ENG-PUDSP21005-R3-PDR.pdf Markup Summary

WATERBURY FILING 1 & 2
PROPOSED MDDP DRAINAGE MAP
OFFSITE MAP

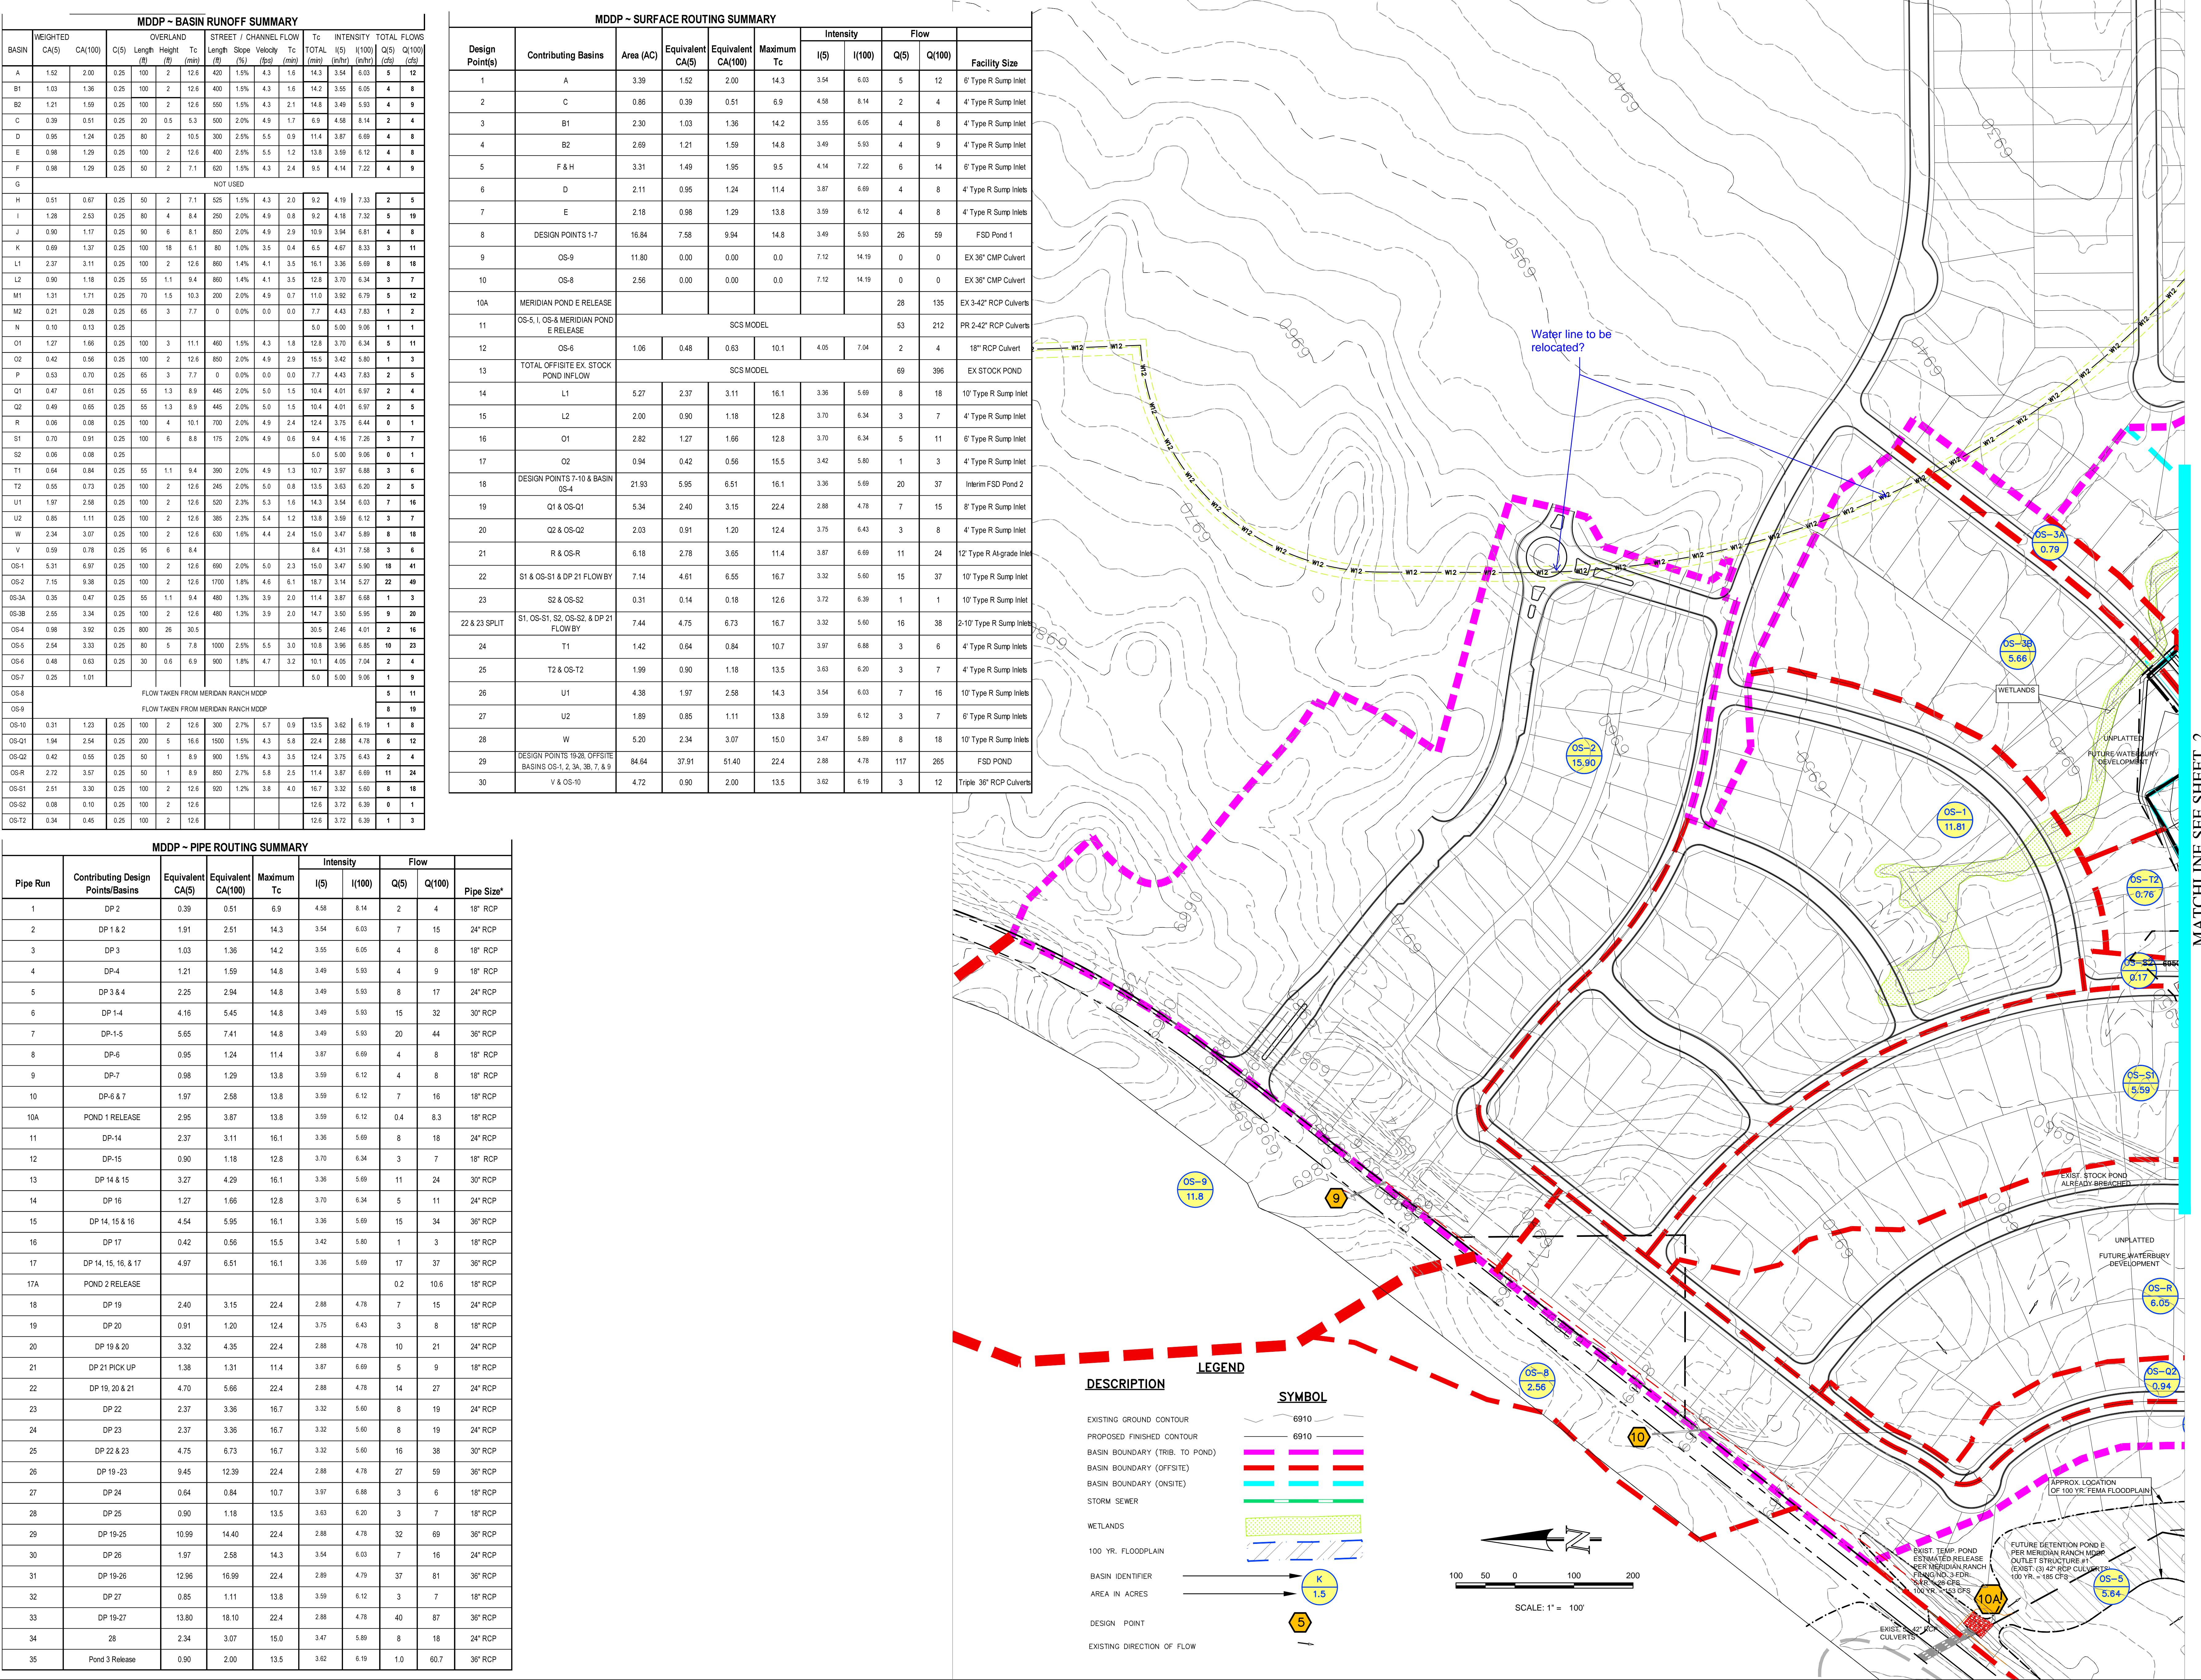
Provide proposed contours

Calculations missing in appendix for these pipes

Highlighted Pipes sizes do not match those in MDDP Pipe run calculations in appendix

east chan pr PDR rev Plan: Plan 01 7/13/2022
700

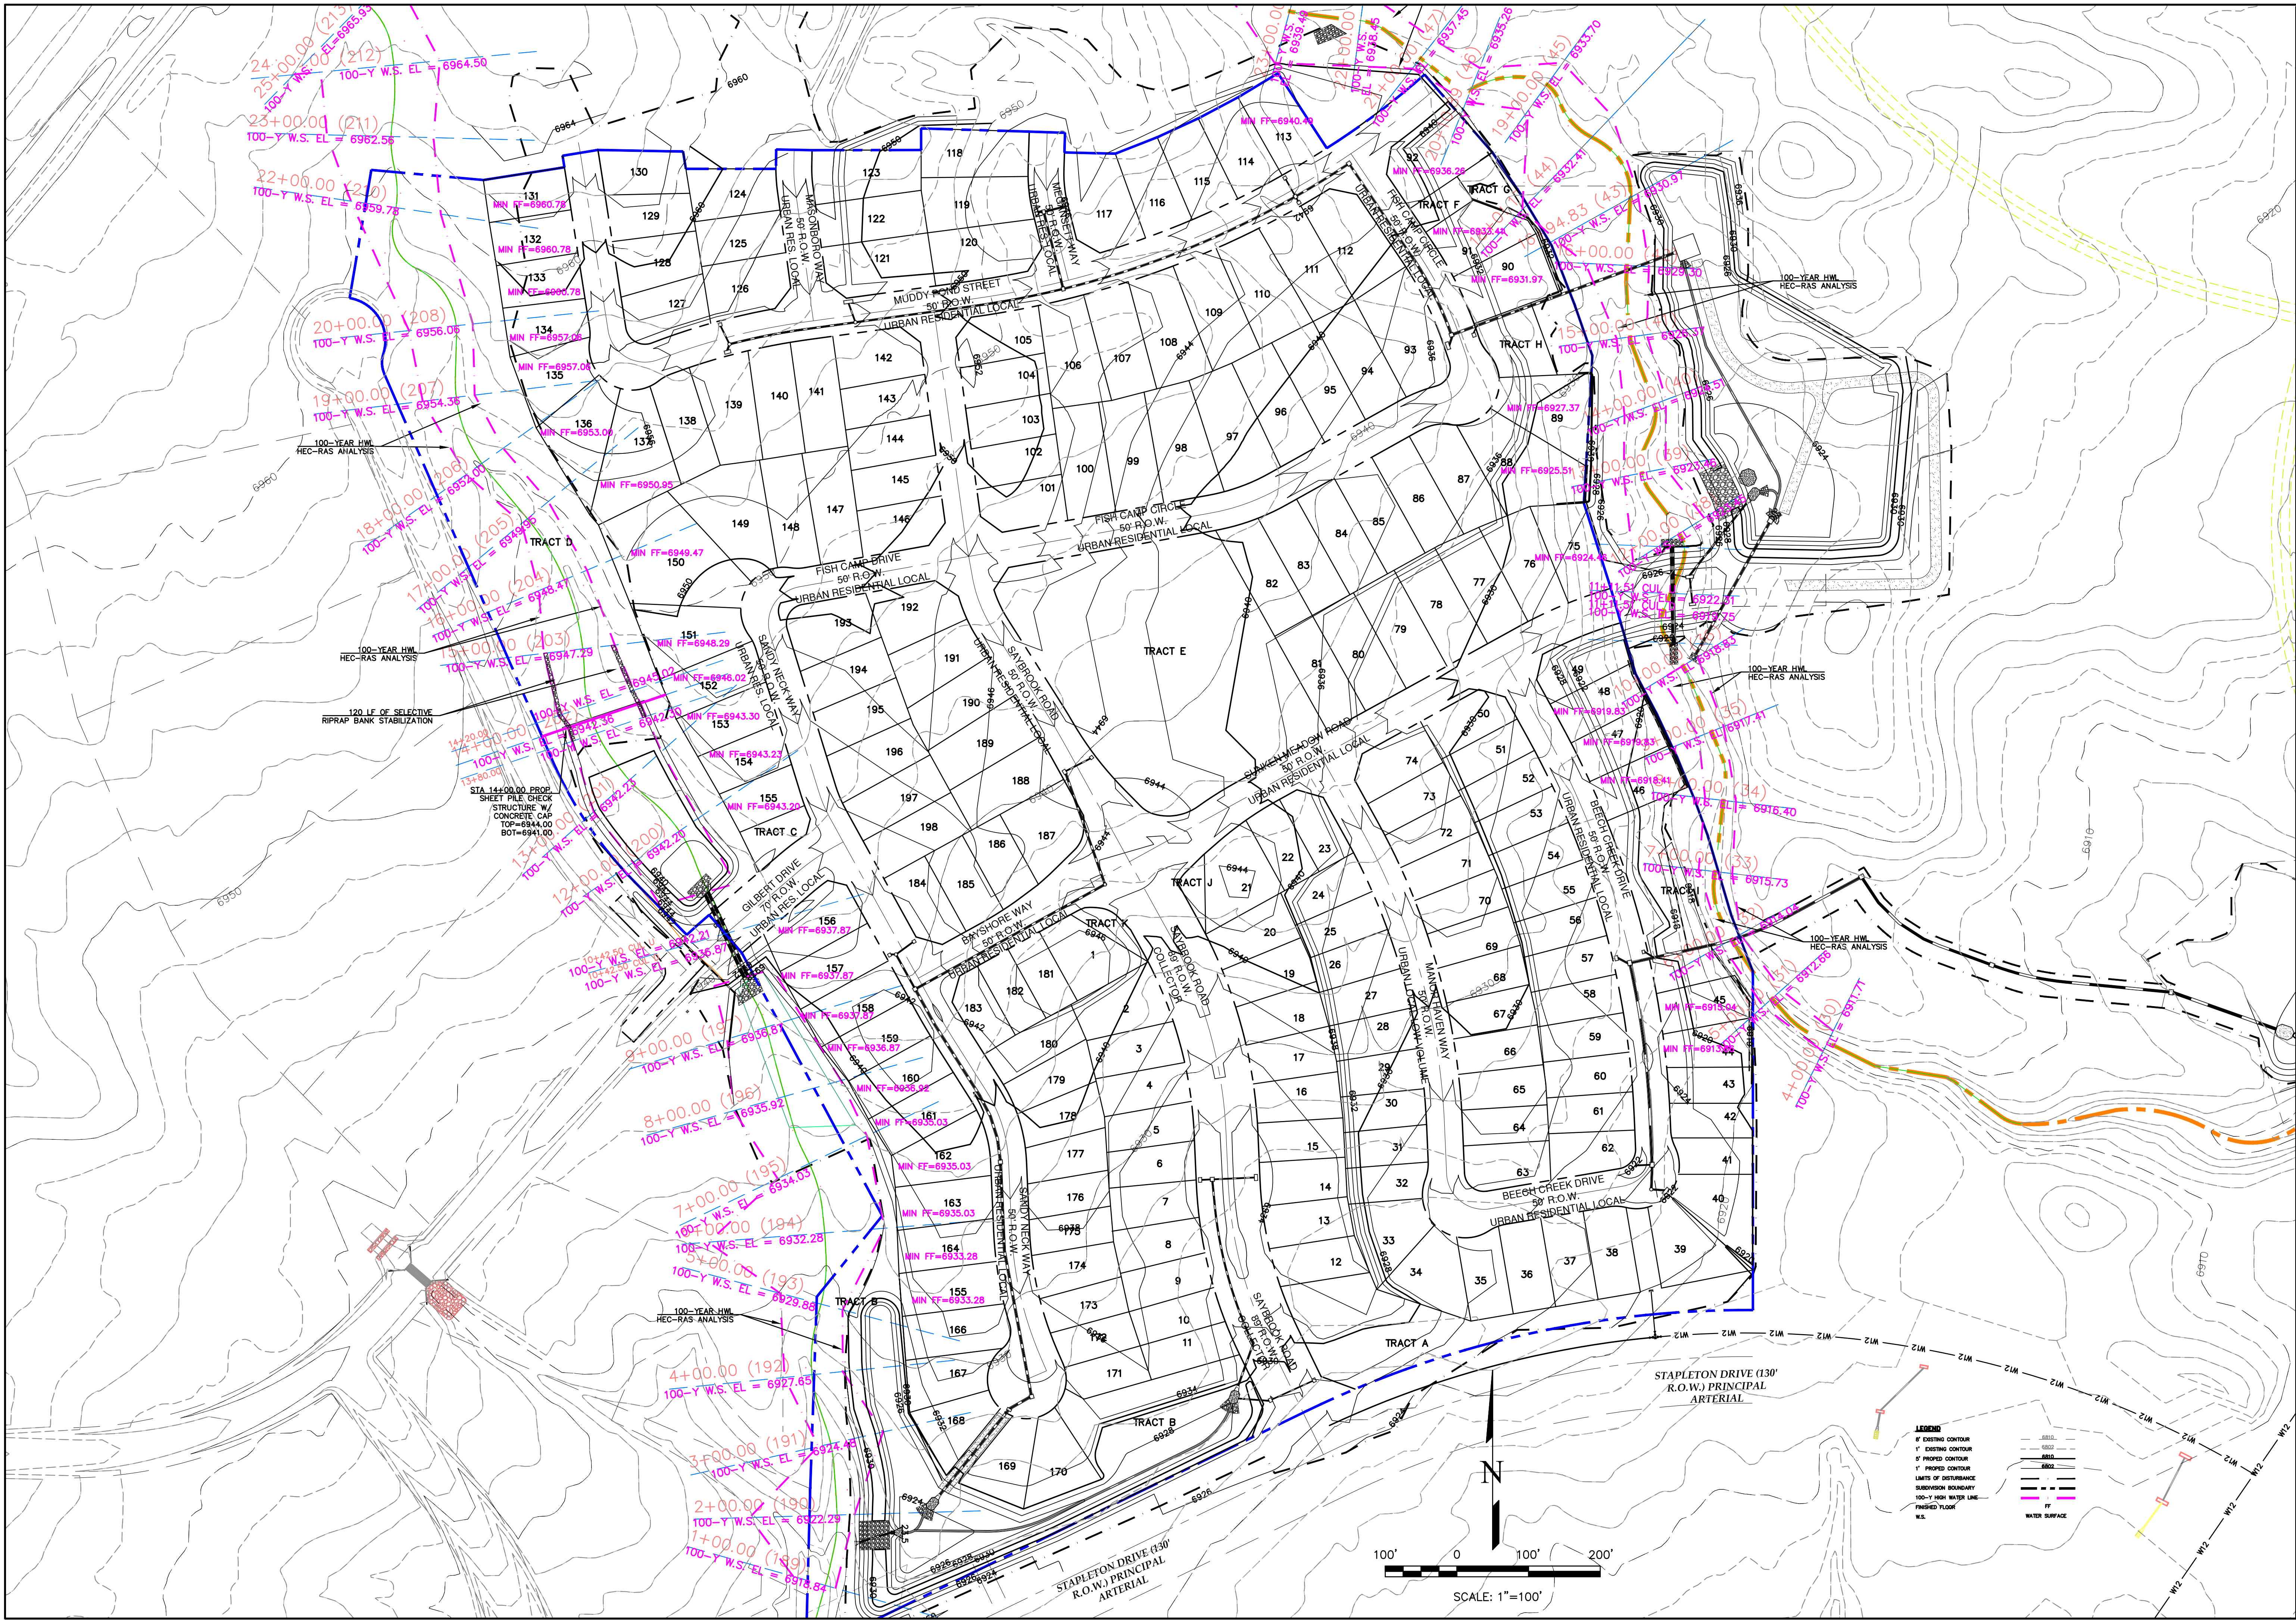
All of the highlighted values indicate supercritical flows

Stabilization / modification needs to be provided where flows are supercritical
